Application No: FP/70/21/PL
Site Address: Kenwood Court 6 The Midway Felpham PO22 7EZ
Description of works: Erection of a car port and rearrangement of existing parking spaces. This application is in CIL Zone 4 (Zero Rated) as other development.

Thank you for your internet representation made on 19th May 2021 which has been recorded as an objection with the comments as follows:

**PROPOSED CAR PORT
PLANS AND ELEVATIONS**

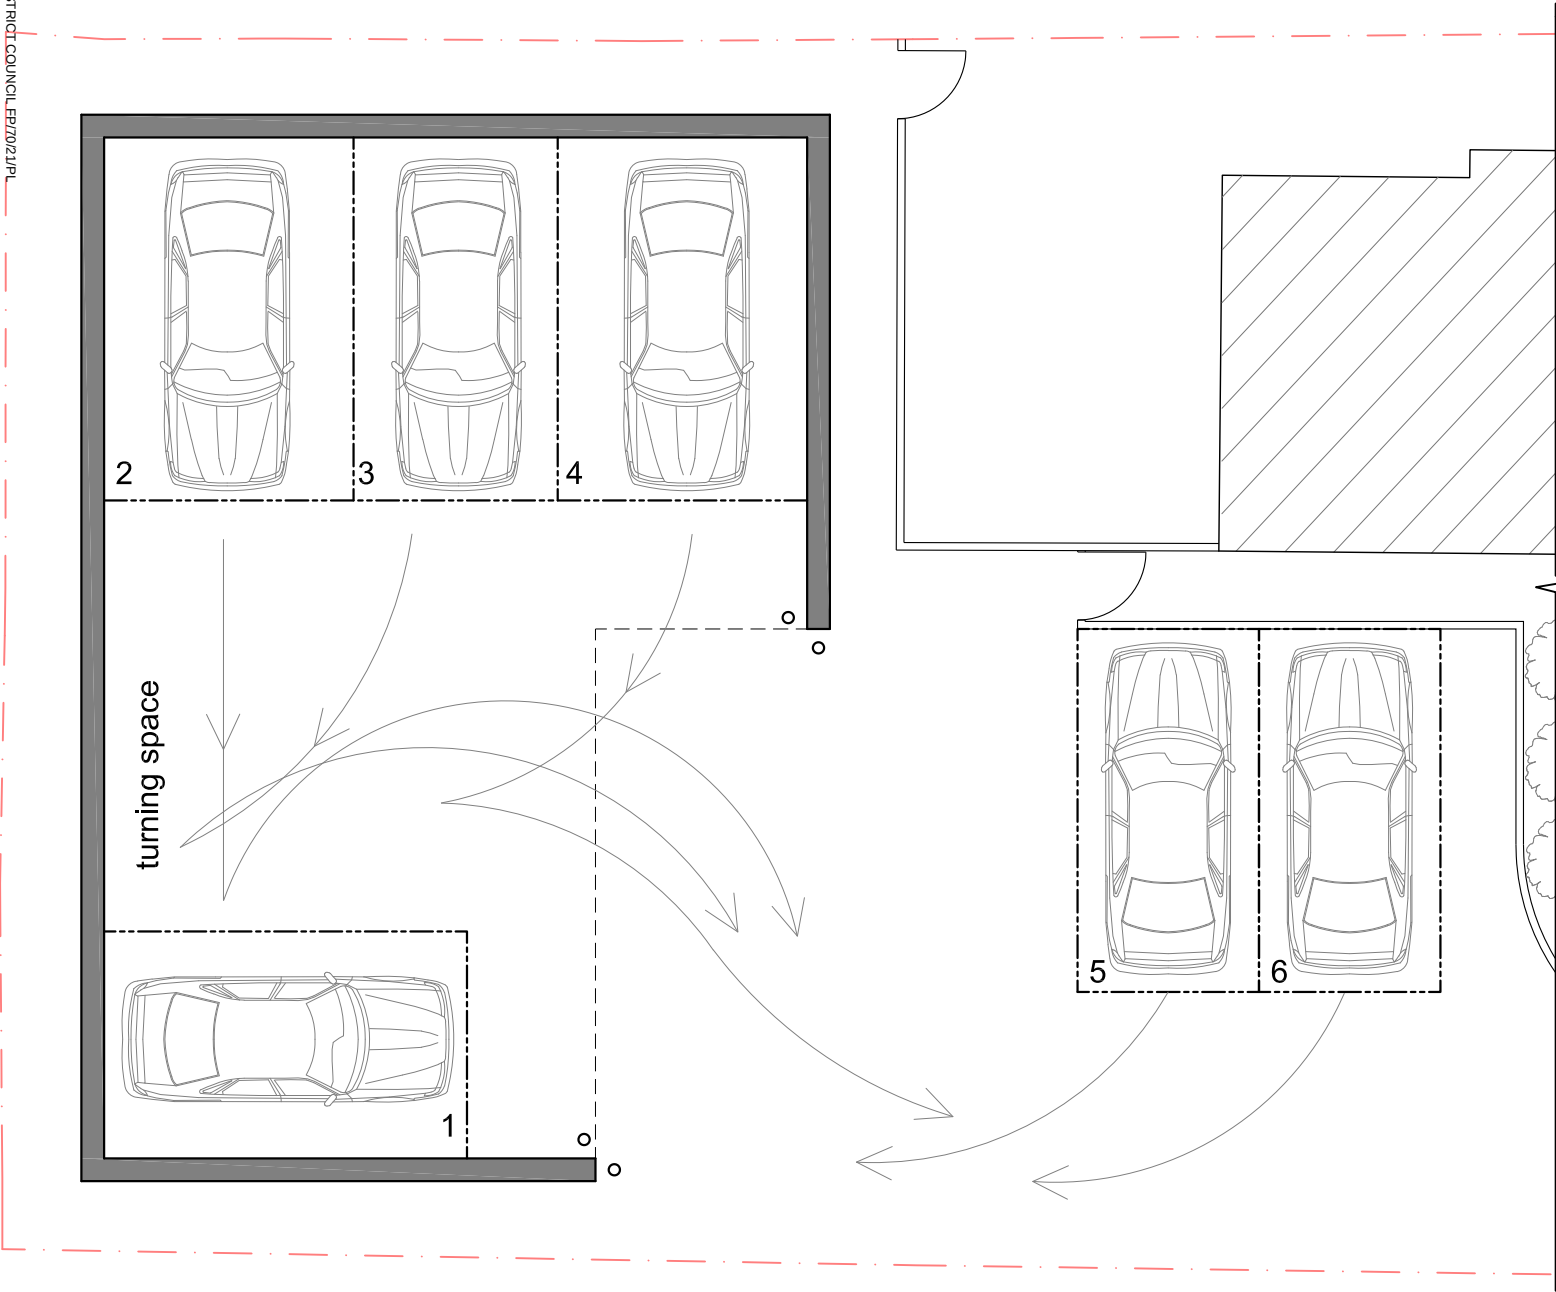
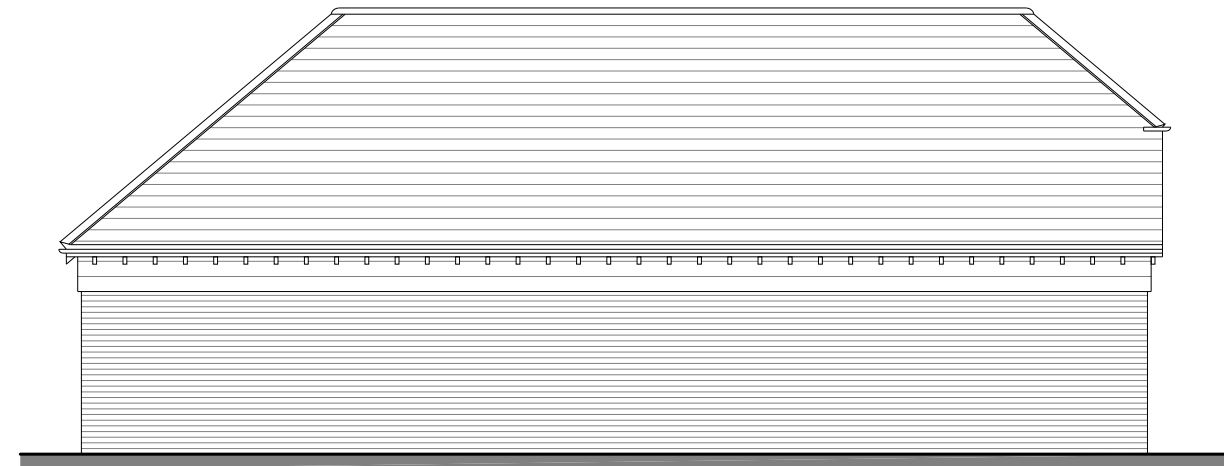
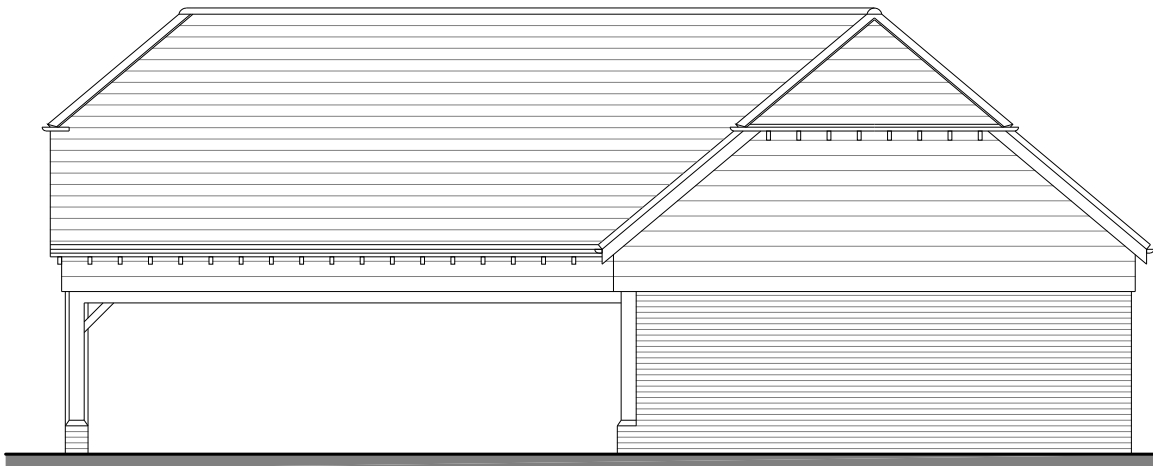
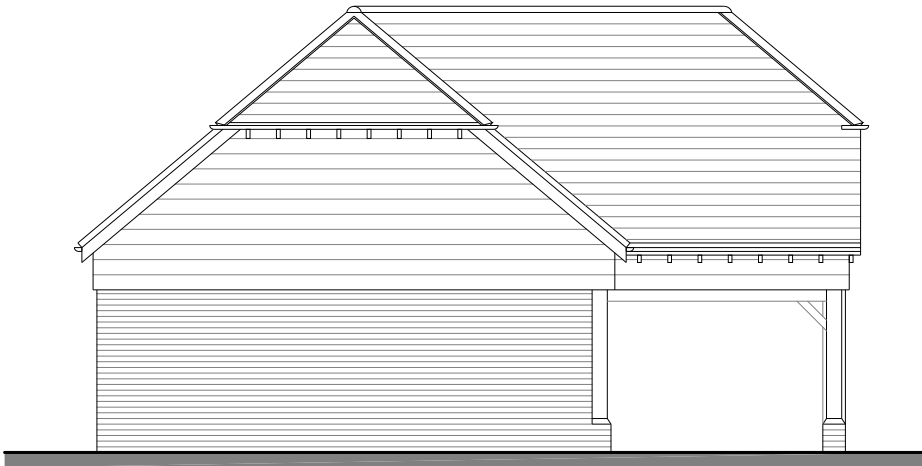
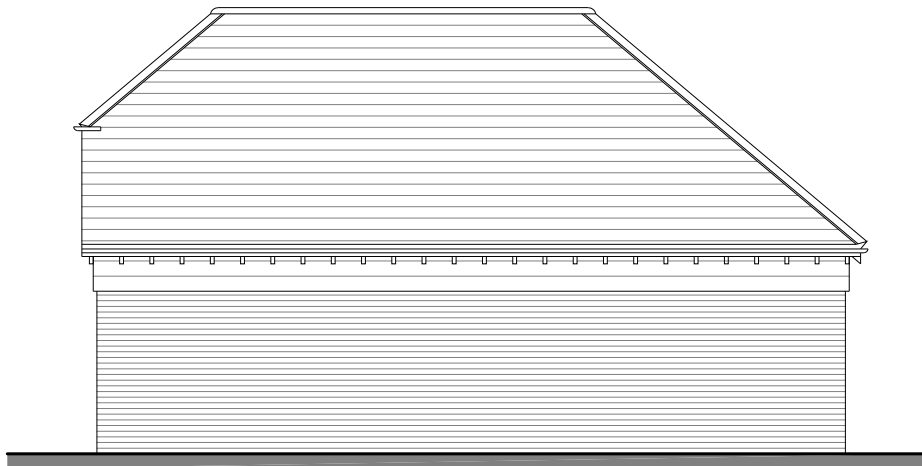
As a tenant at the property I strongly object to the proposal. We do not want the frontage turned into a car park, nor do we want to reverse into the road from the parking space. In addition, the disturbance of the newly laid gravel will scatter across the pathway, blocking the way for my mobility scooter. As for the rear, the plans are not only an eye sore but totally un-necessary. I have lived here 16 years, we do not need or want a carport. The residents have not been consulted on their requirements. We feel this is the prelude to something bigger which will deprive us of the rear car carpark ongoing.
